Re: **Veterans Integration Center Phase 3 at 2701 Mulberry St SE.
Erosion and Sediment Control Plan M15E054 – (SWQ-2026-00005)
Engineer's Stamp Date 5/9/23**

Based on the information in your submittal received on 1/23/26, the ESC Plan cannot be approved until the following comments are addressed.

ESC-1

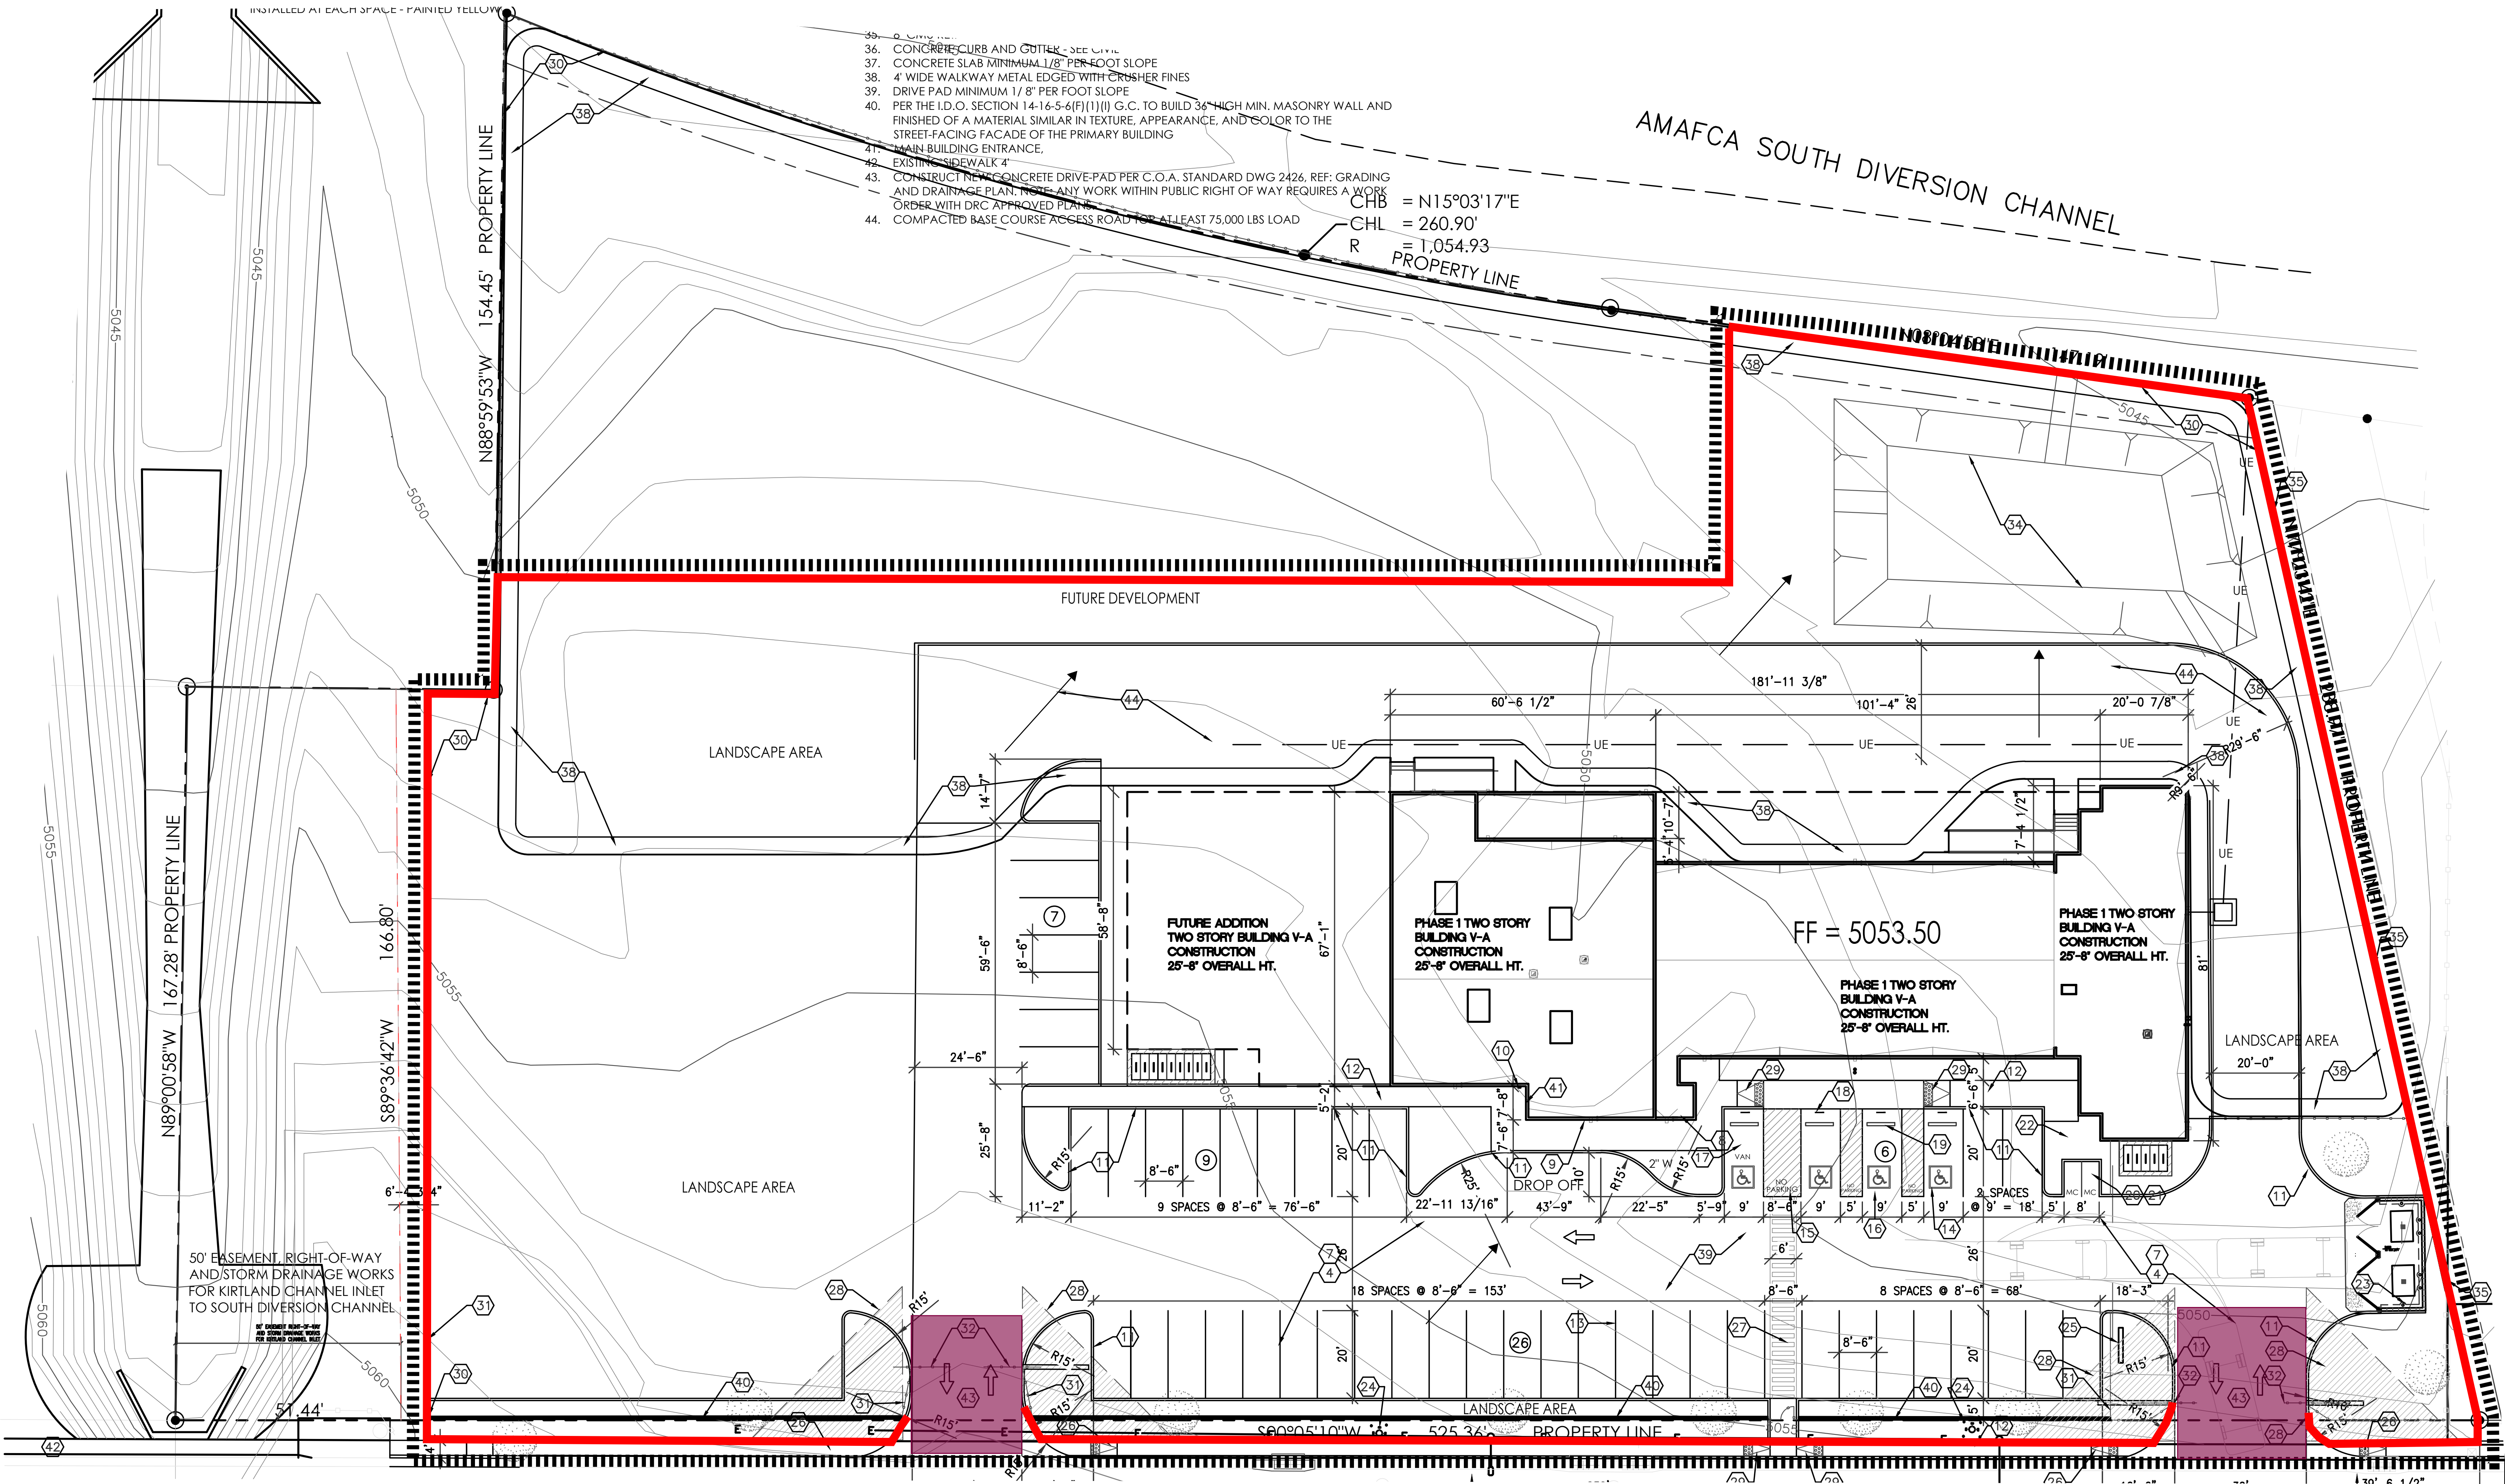
3. The improvements on your ESC Plan for phases 1 and 2 are complete, but the new phase 3 improvements are missing. You must update and revise the ESC Plan to differentiate between existing and proposed structures. The limits of disturbance for phase 3, including construction support activities, are missing and must be shown accurately on the ESC Plan, along with stormwater controls prepared in accordance with good engineering practices by erosion control specialists.

5. The SWPPP must include site-specific interim and permanent stabilization per CGP 9.6.1.c.i. The Landscape Plan can be used to satisfy this requirement and should be submitted separate from the ESC Plan with the application to the Stormwater Quality Section of the Planning Department, and it should be included in the SWPPP. Provide a specification on the ESC Plan for any disturbed areas not covered by the Landscape Plan.
